Existing Plans & Elevations

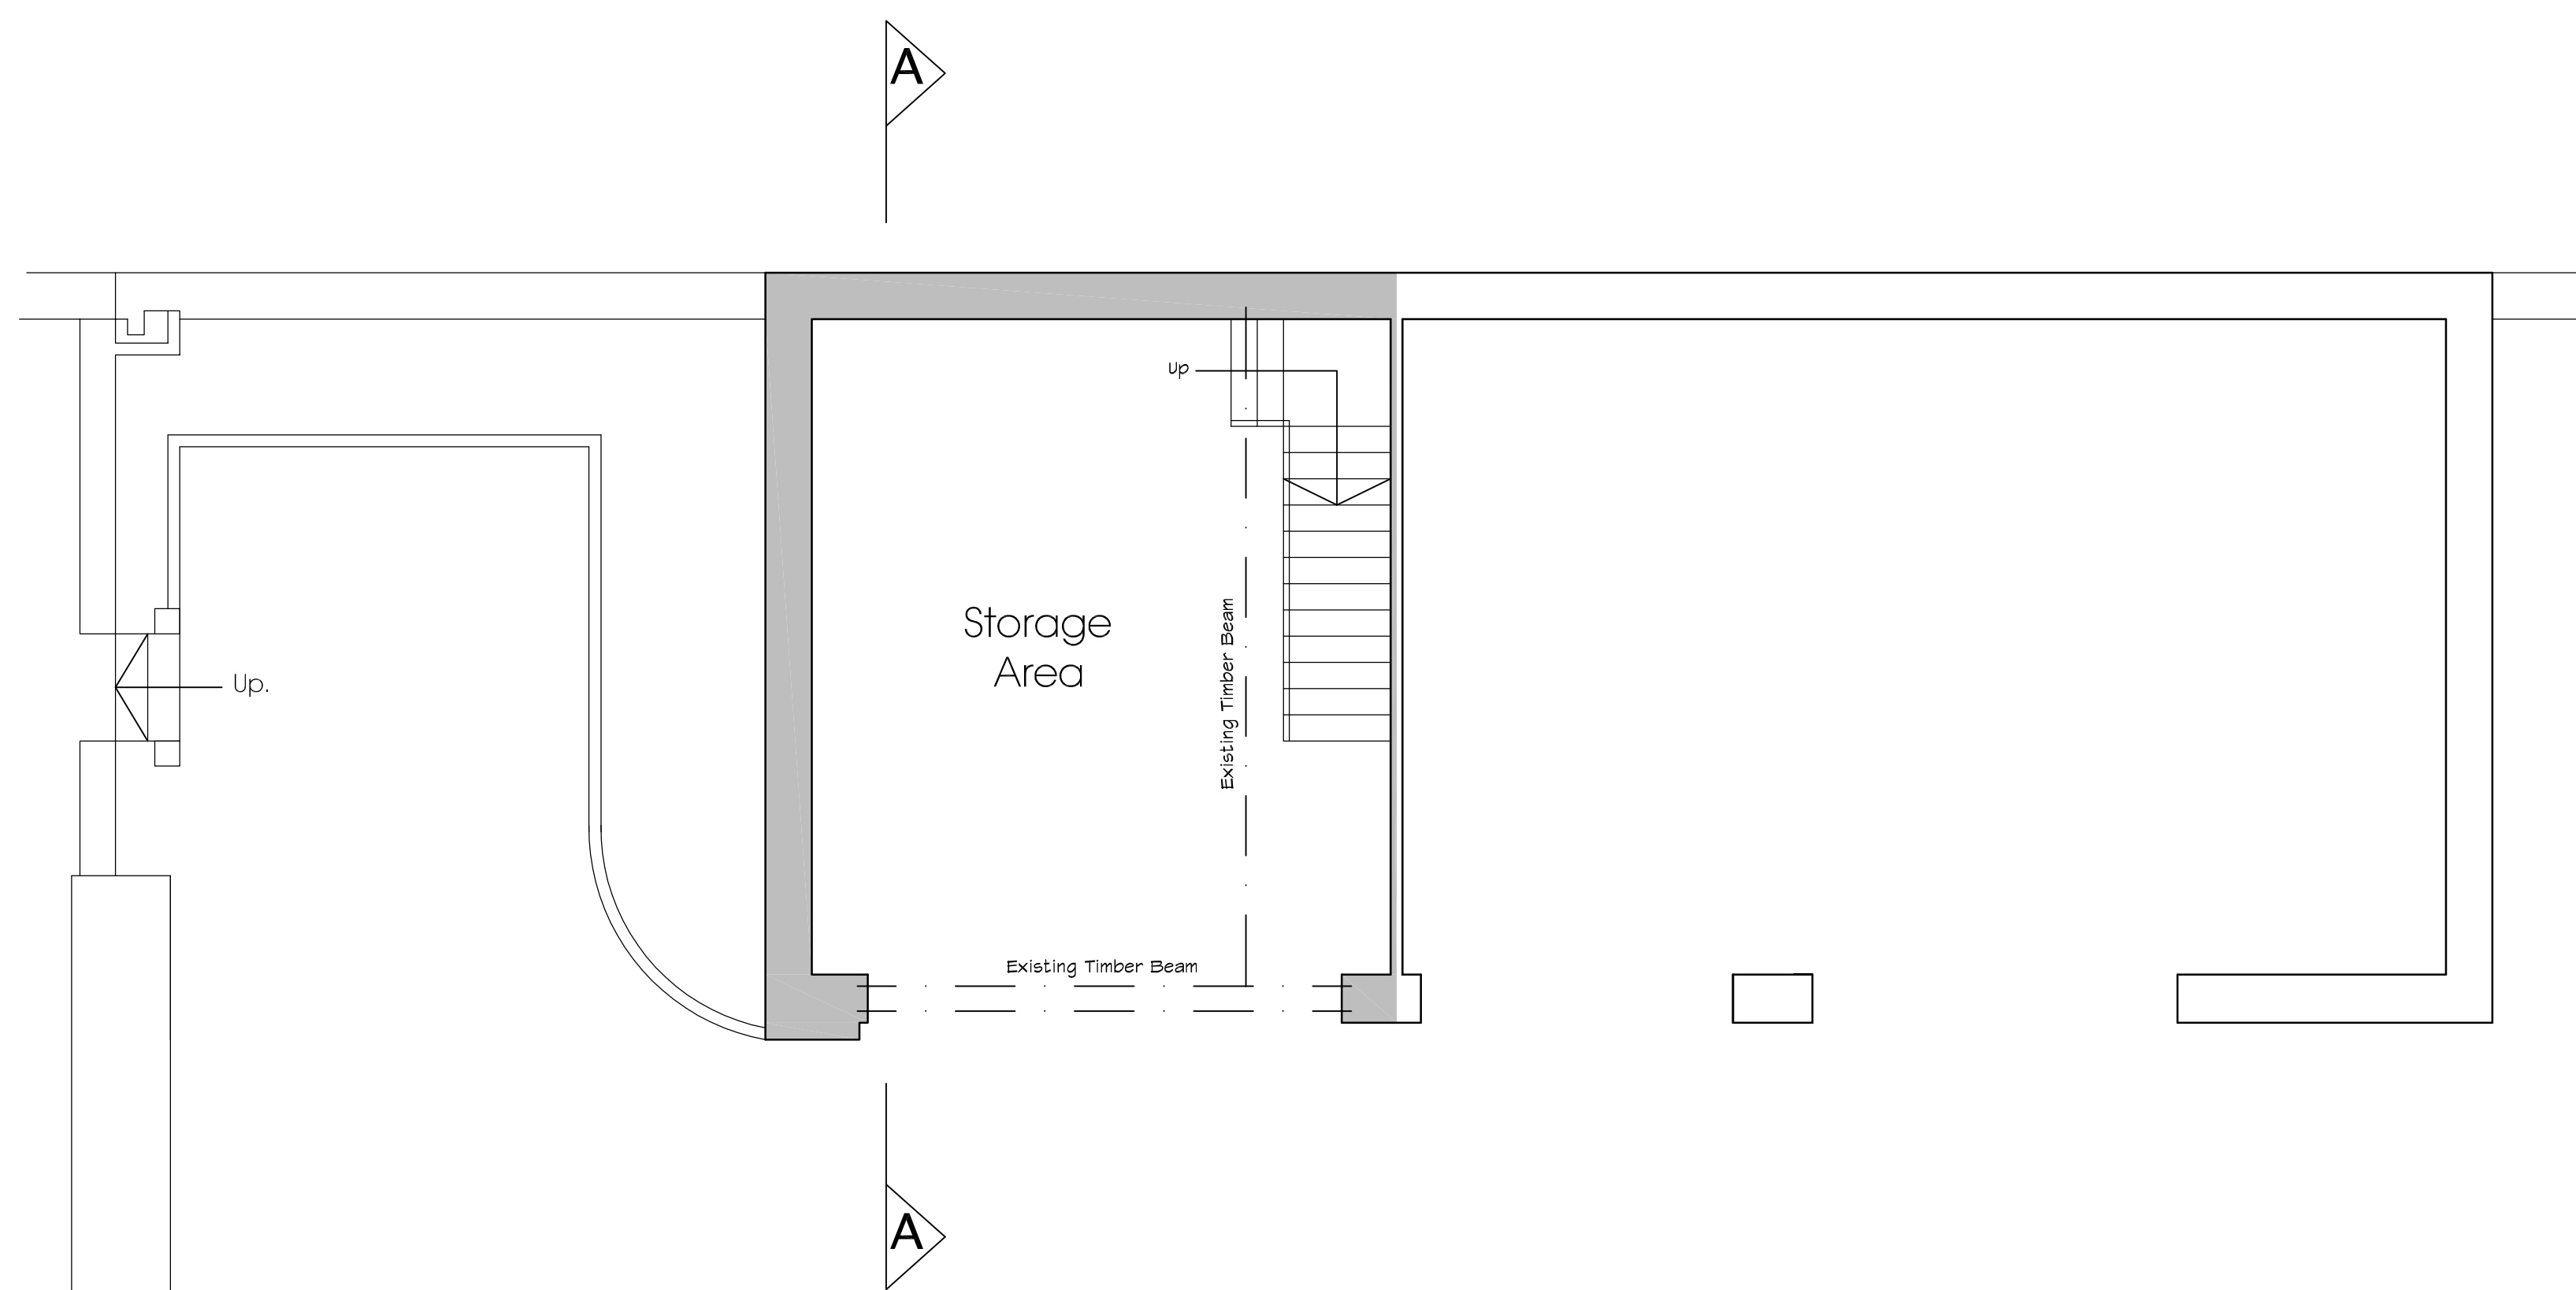
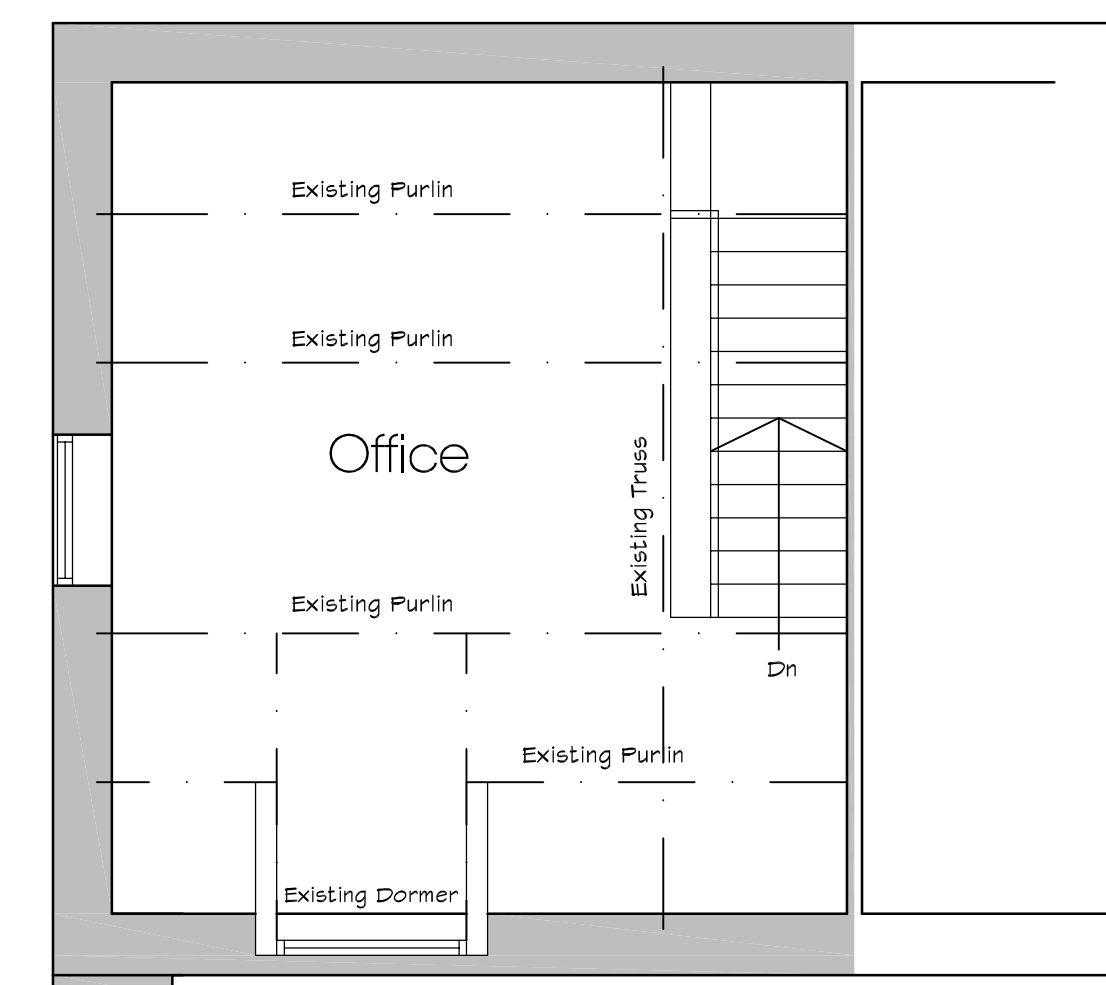
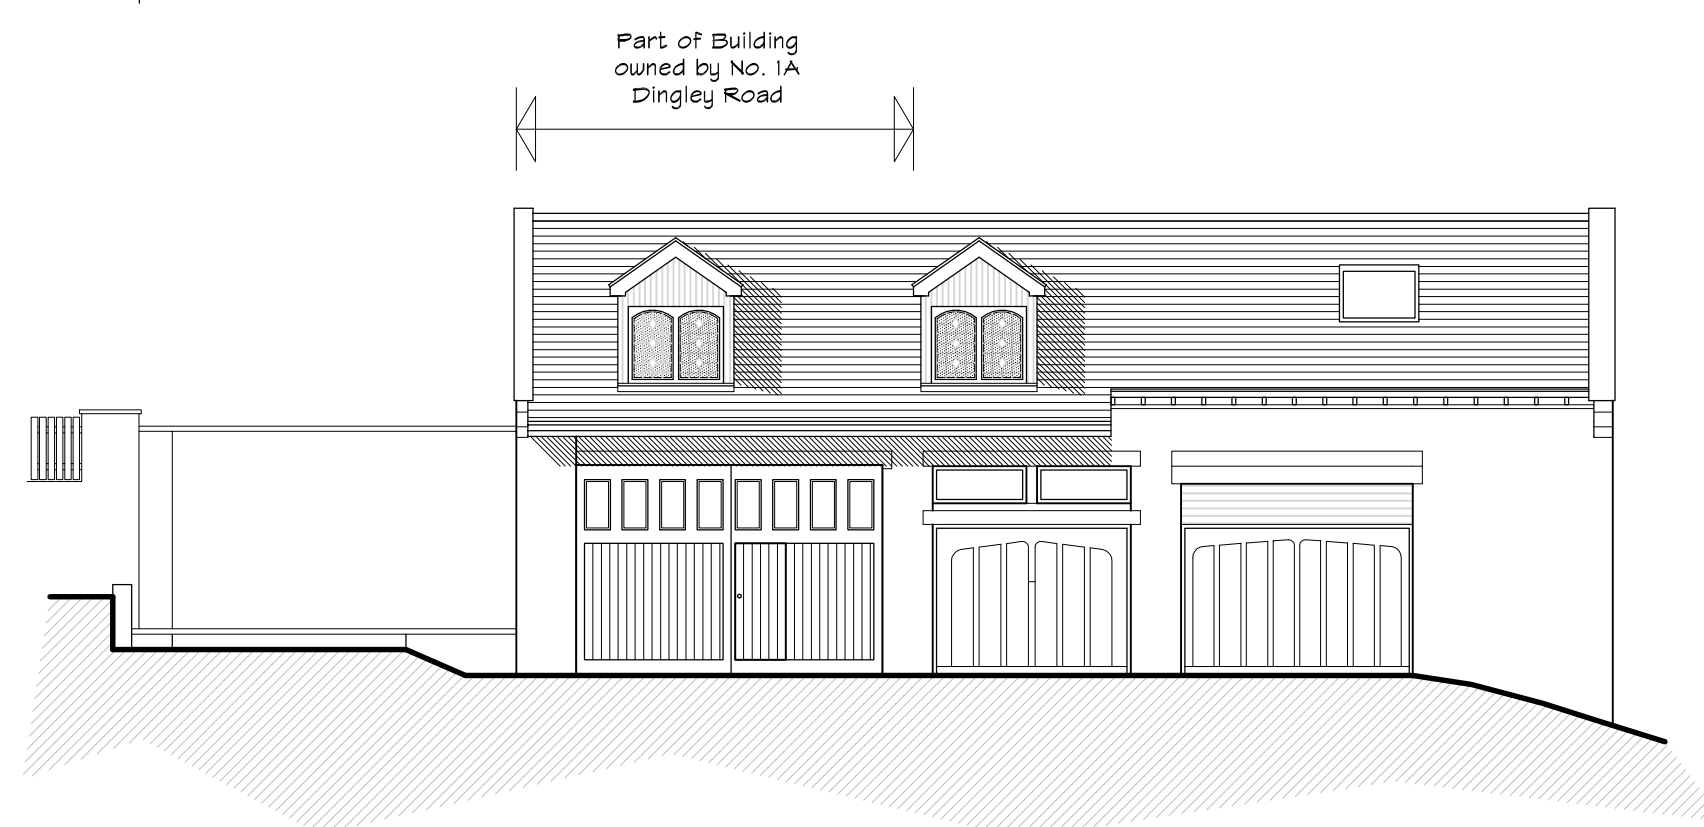
The update went on to state that, *'Furthermore, the existing plans show the annex at first floor to be used as an office, which benefitted from a habitable opening. Therefore, whilst the residential use may be more intense, the relationship between these two neighbours has already been established.'*

In response to this, we would question whether the 'office' is actually used as an office. Whilst on a recent site visit, we ended up engaging in conversation with the applicant. He firstly admitted that he's a builder by trade. He therefore certainly doesn't work from home. Even if the office is occasionally used for business or personal use, a bedroom within an annex, rather than an office within an outbuilding, would result in a far more intensive use. Furthermore, the garage was left wide open when the applicant went out. Why would someone do this if the office contained expensive electrical equipment e.g. computers, and important documents etc? We are of the opinion that the office is not used as an office at all. As such, we simply do not feel the existing office should be viewed as an existing habitable room in this instance.

Proposed Plans & Elevations

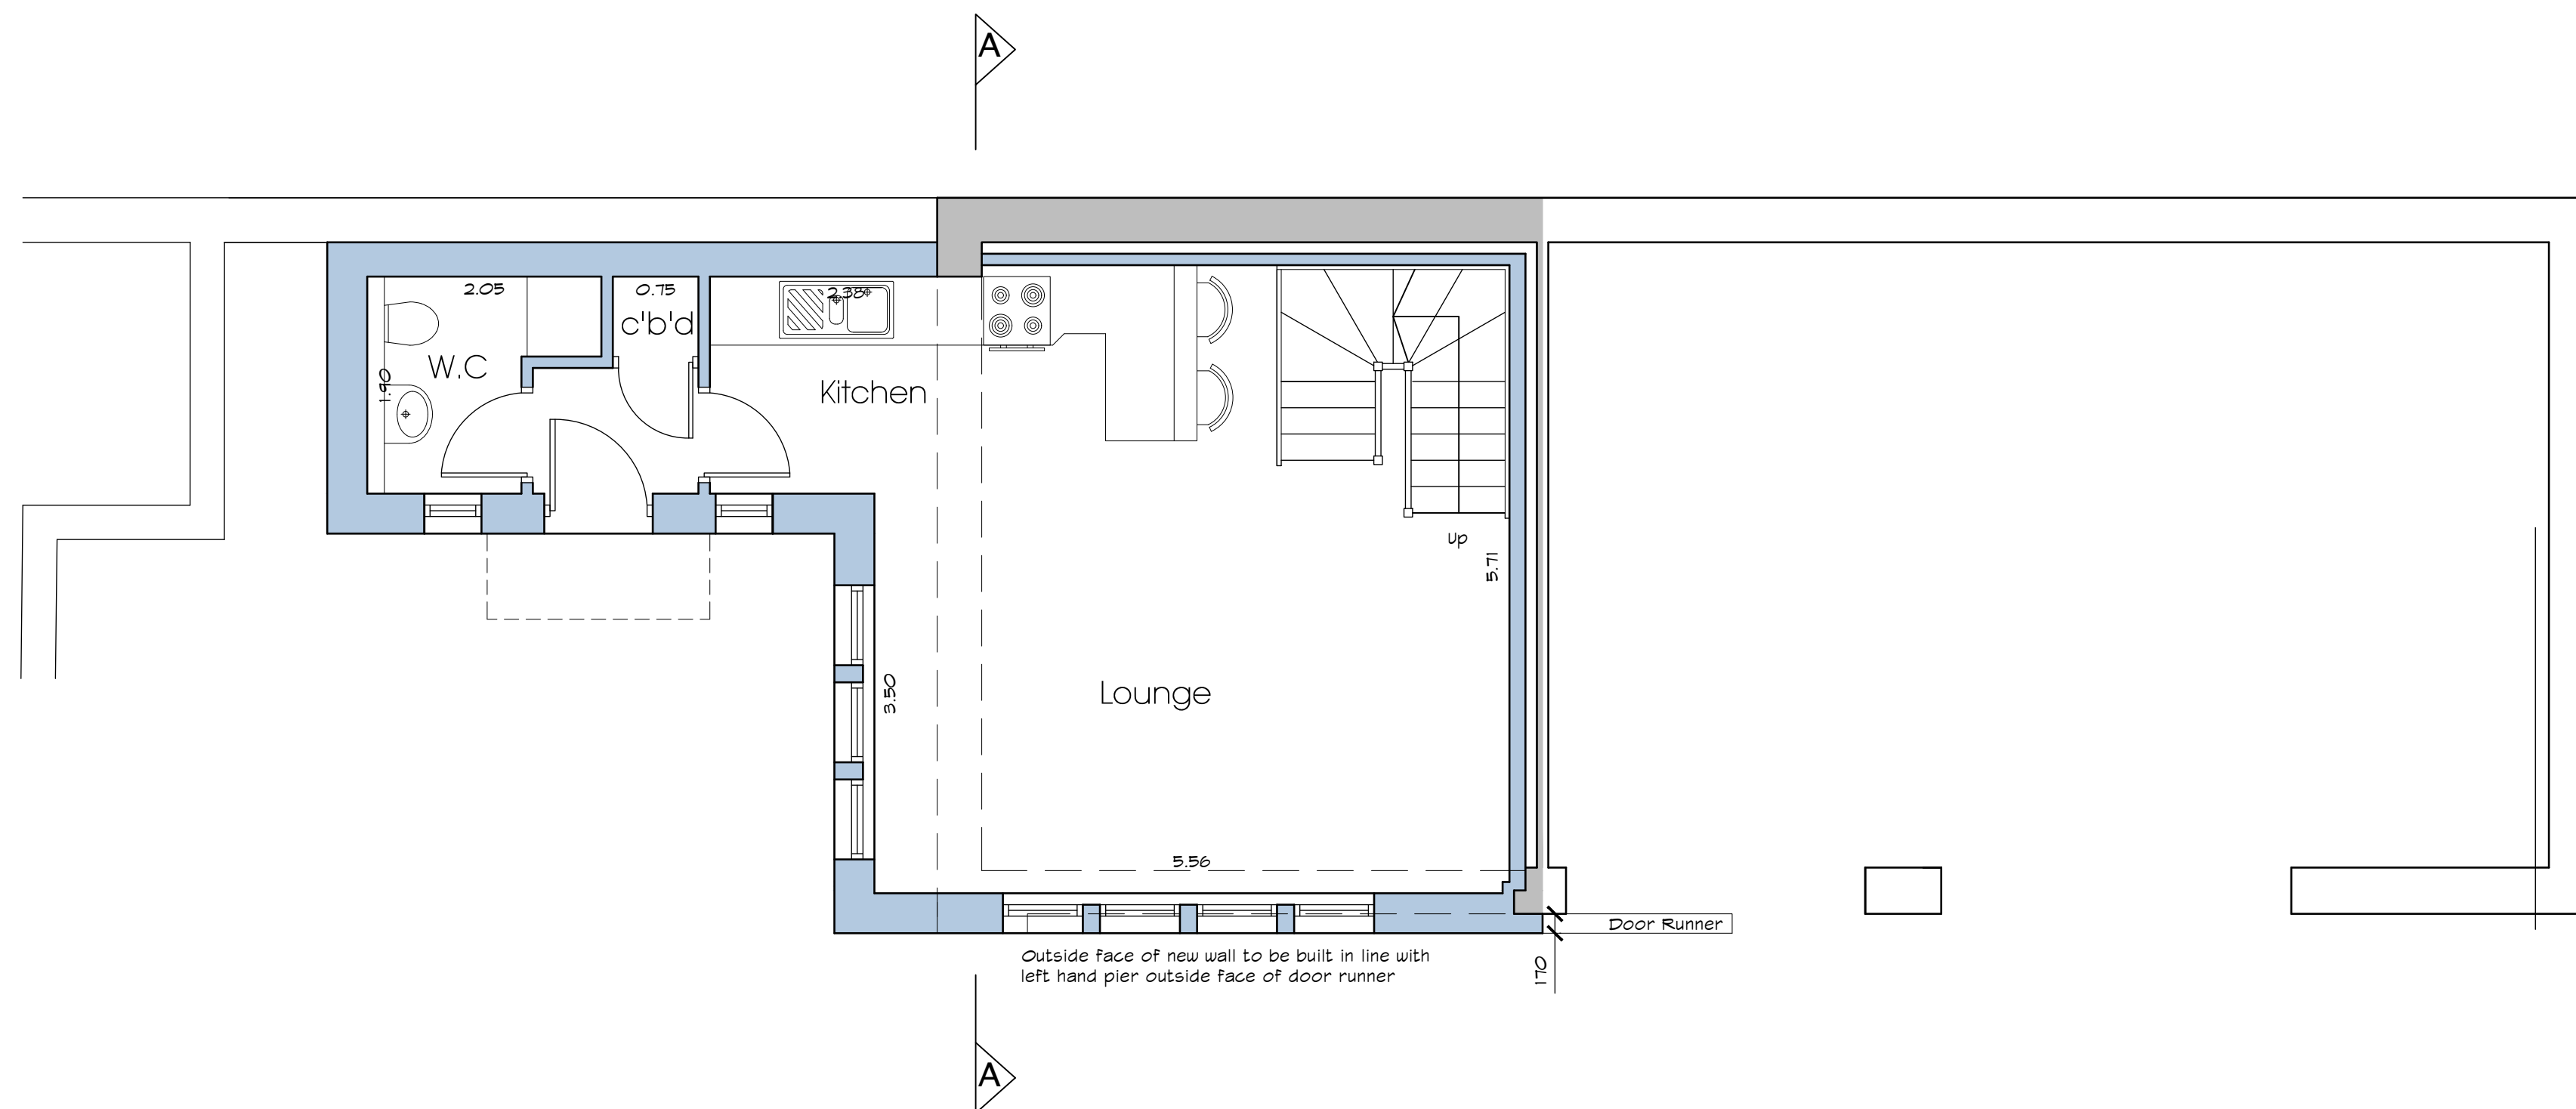
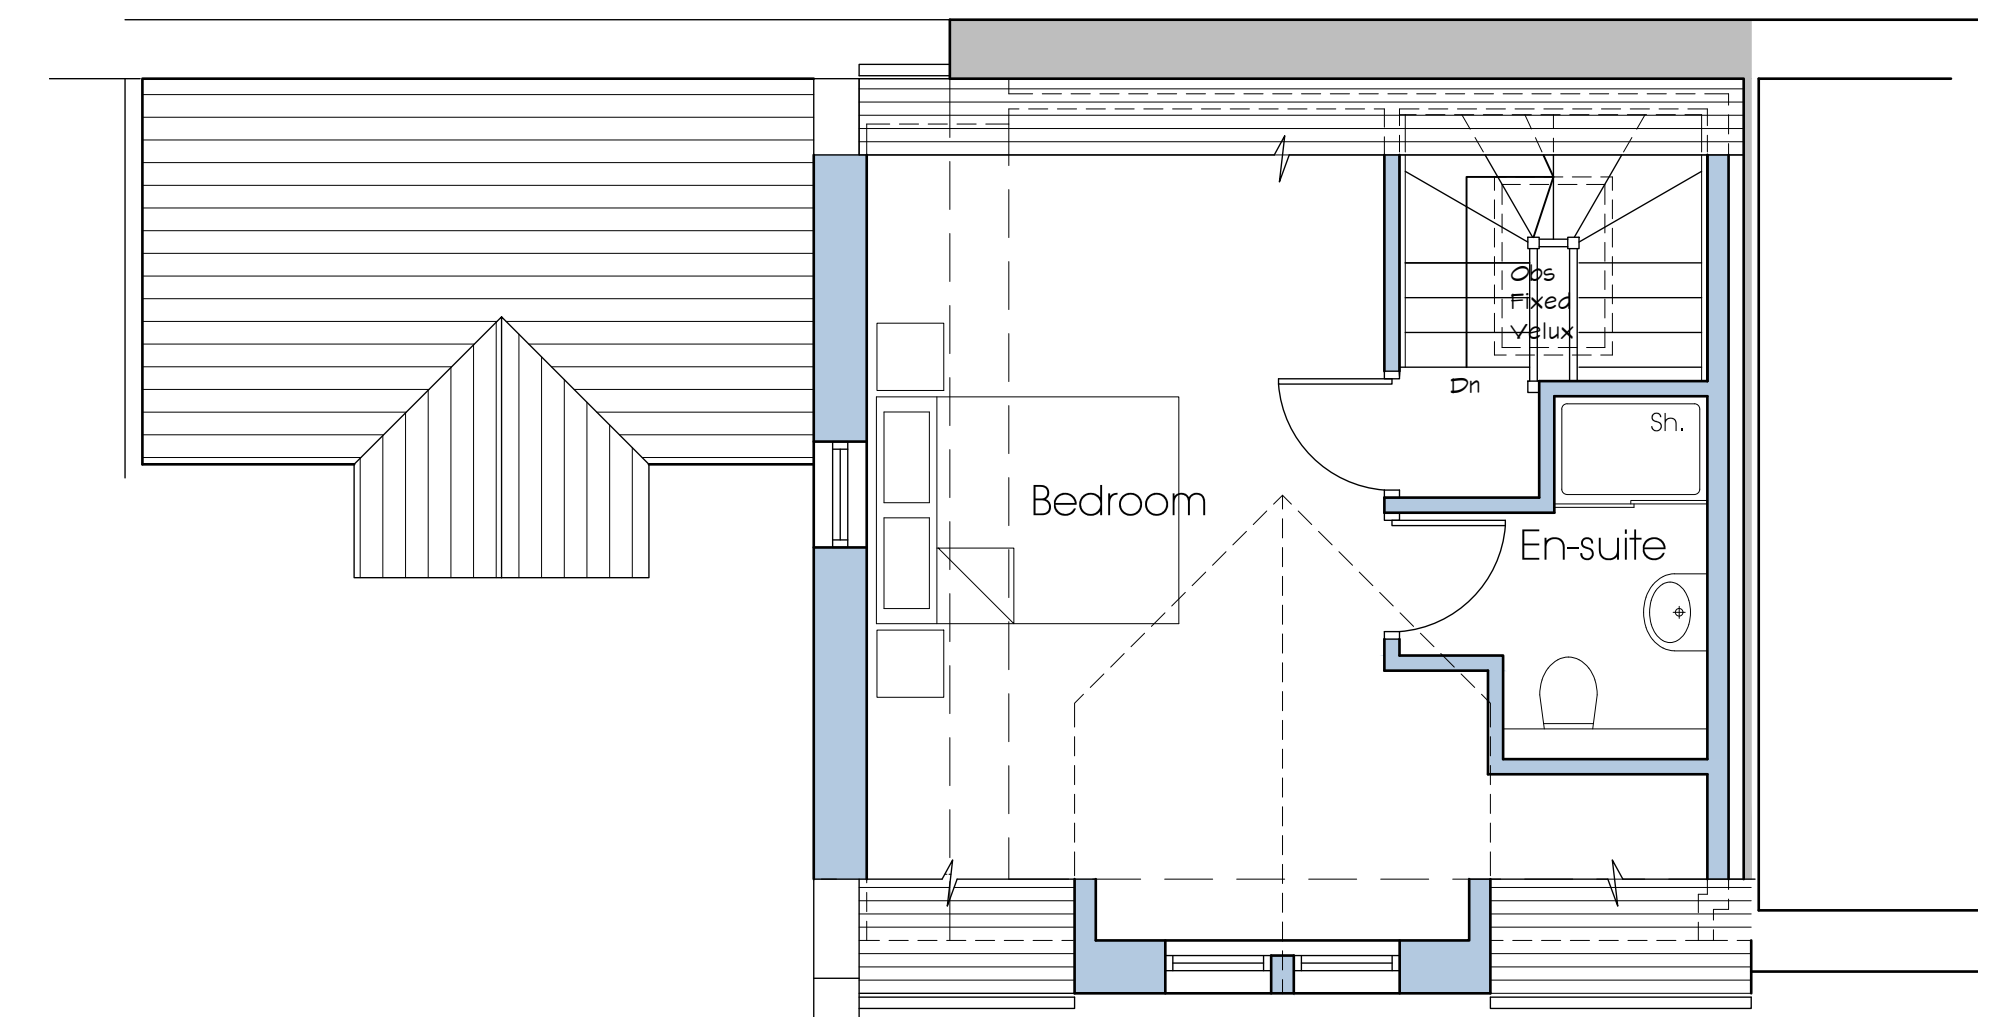
The update stated, *'the openings proposed within the annex would be significantly screened by a large hedge which appears to be within neighbouring land (at no. 1b).'*

The hedge referred to is within our client's land and not within the applicant's land and therefore control. As such, the hedge could be reduced in height or removed entirely at any given point and it should therefore not form part of the planning and decision making process in this case. Our client has three windows on the side elevation that face the proposed annex. On the ground floor there is a utility room window and on the first floor a bathroom and bedroom window. It should be noted that the bedroom window is the only window to this room. It isn't a secondary window. The separation distance of 14.2m from this bedroom window to the proposed bedroom window in the annex falls well below the recommended 21m in the SPD and we are astonished that officers find this to be acceptable.

In addition, the existing garage is proposed to be turned into a lounge. The separation distance of 11.4m from what would be a habitable room window to our client's non-habitable utility room window, also falls below the recommended 12m in the SPD. A lounge would most certainly be a more intensive use than the existing garage, and given the separation distance, the proposed development would create additional overlooking.
